From: Amanda Scholes on behalf of Planning.Responses
Sent: 30 November 2017 08:41
To: Planning Scanning
Subject: FW: Objection: WA/75/17/PL
Attachments: Land Adjacent Copse Lane (1).pdf

[REDACTED]
Sent: 29 November 2017 19:03
To: Ross Leal
Cc: Planning
Subject: Objection: WA/75/17/PL

**Planning Application WA/75/17/PL
Land Adjacent to Sunny Corner, Copse Lane, Walberton**

SIDE / SOUTH WEST
elevation

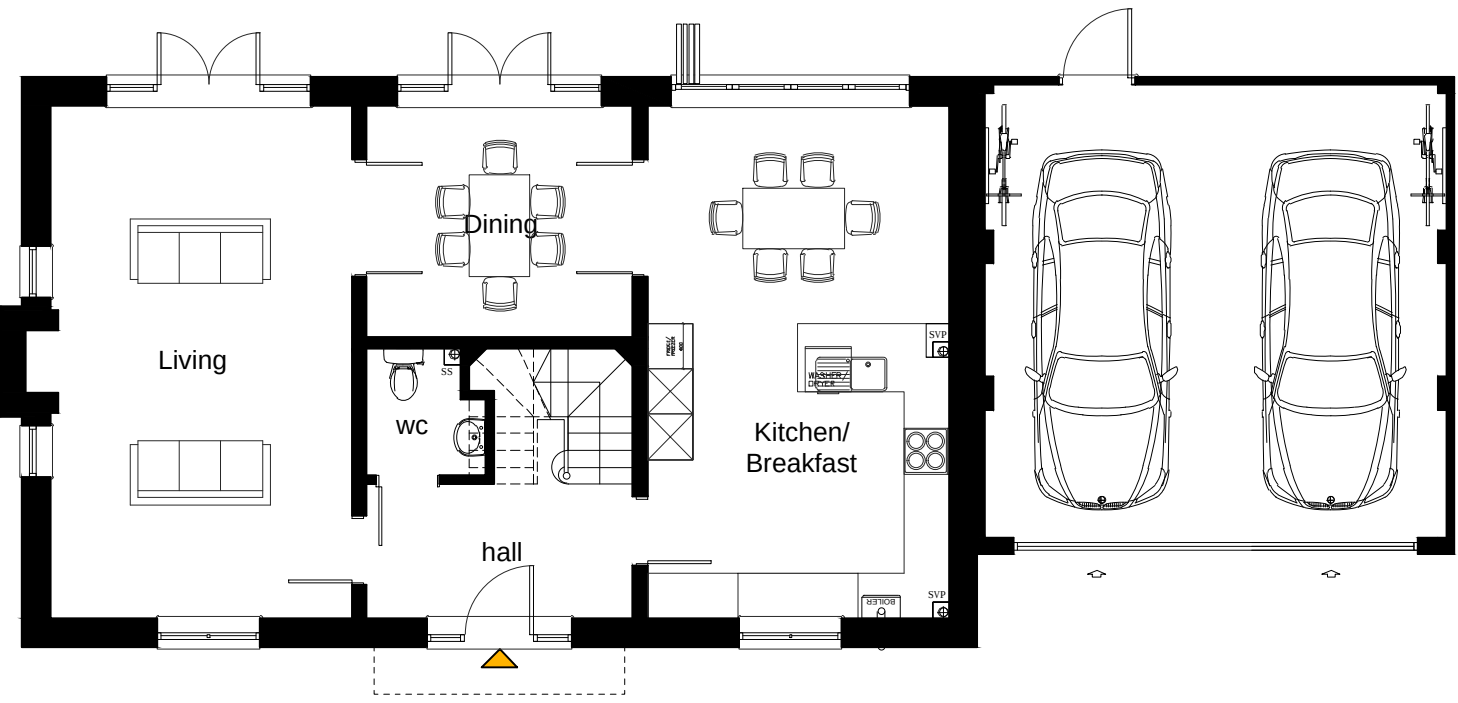
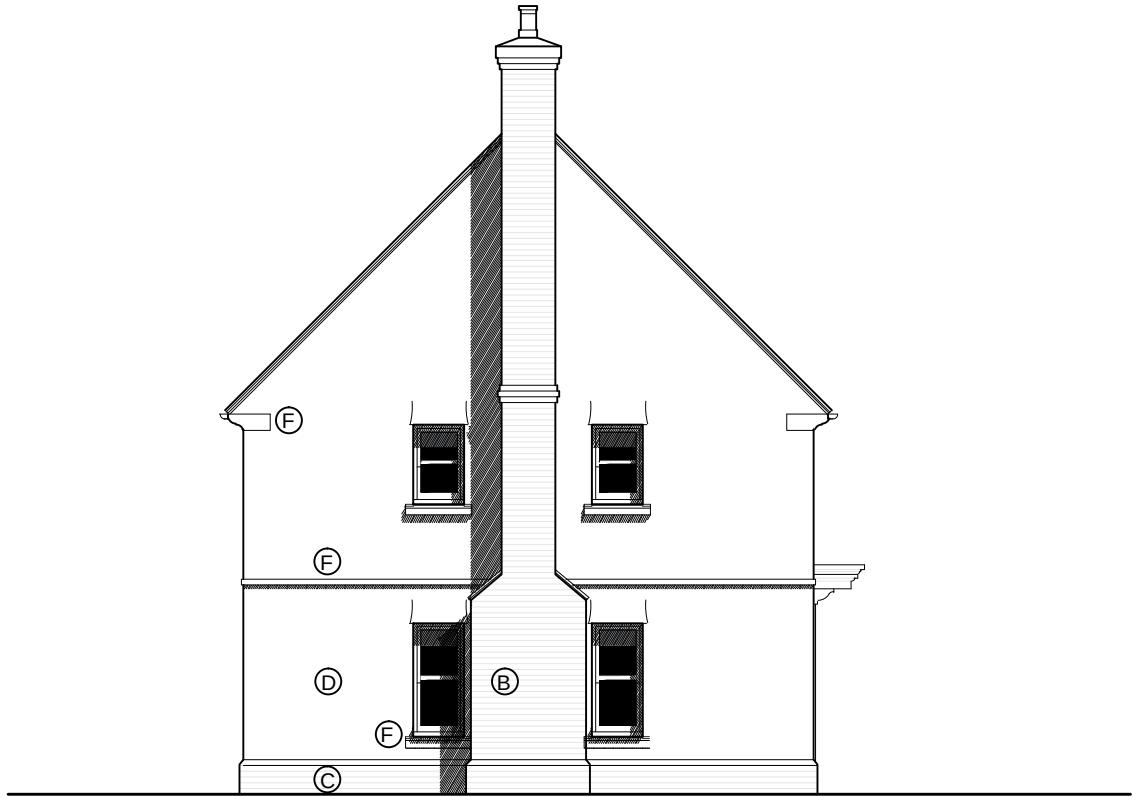
This issue is of particular relevance when the proposals for Plot 1 are examined. The proposal for the dwelling on this plot is for a house with two storeys. The elevation drawings reveal four windows - two on each floor- on the South West Side which face and will overlook our land and house. We are concerned, at this loss of privacy. We note that the orientation of other houses on this development were changed to avoid the perception of being overlooked and we would ask that this courtesy be extended to meet our concerns.

**Figure 7.** The blue lines indicate the proposed additional planting to support existing hedgerows and the yellow line indicated the proposed new hedging.

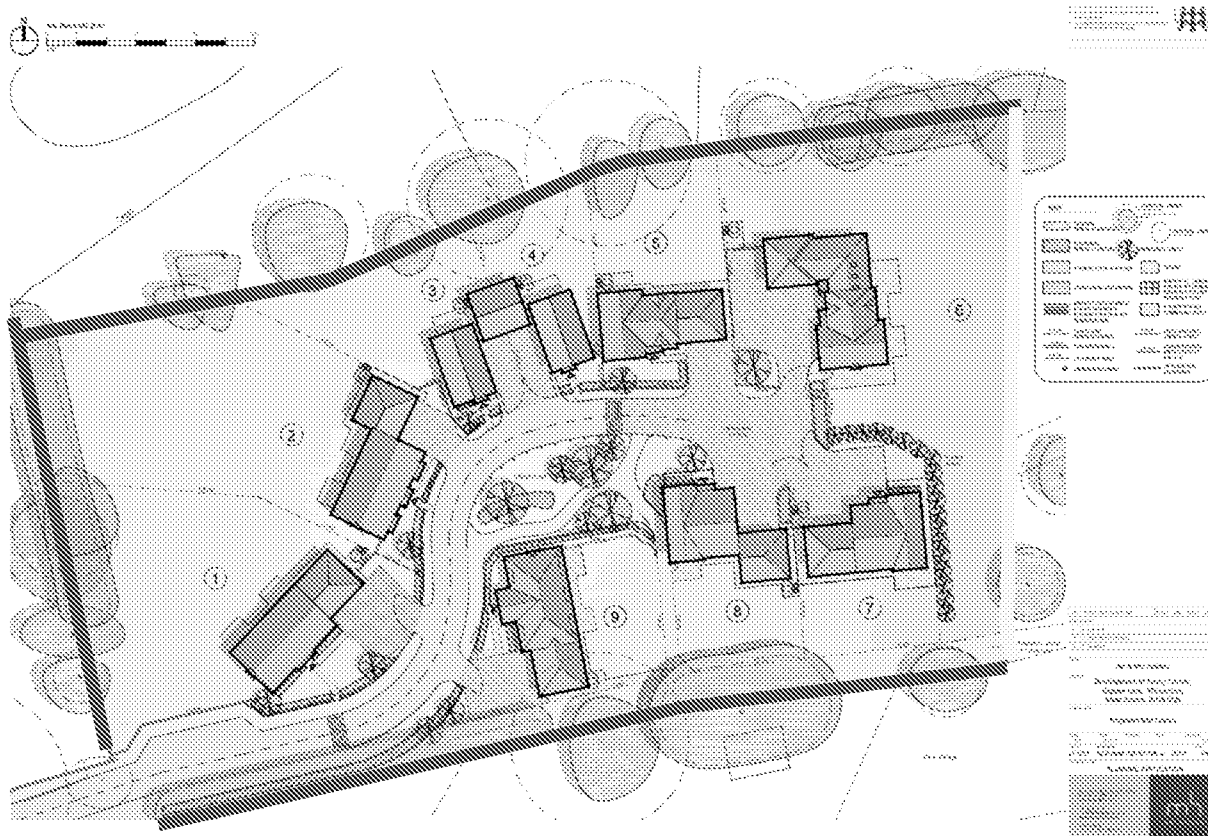
The boundary hedging between our land and the proposed site for development is incomplete and in the winter, it becomes threadbare in places. The proposal contains the mention of enhancing the hedging, but no specifics are given as to the extent and nature of this provision.

We have been in communication about this and the intention to reinforce this hedging has been made clear. However, we would feel more reassured if this was a requirement of any

permission granted that the hedgerow should be supplemented and provided for along the entire length of the boundary with our land.
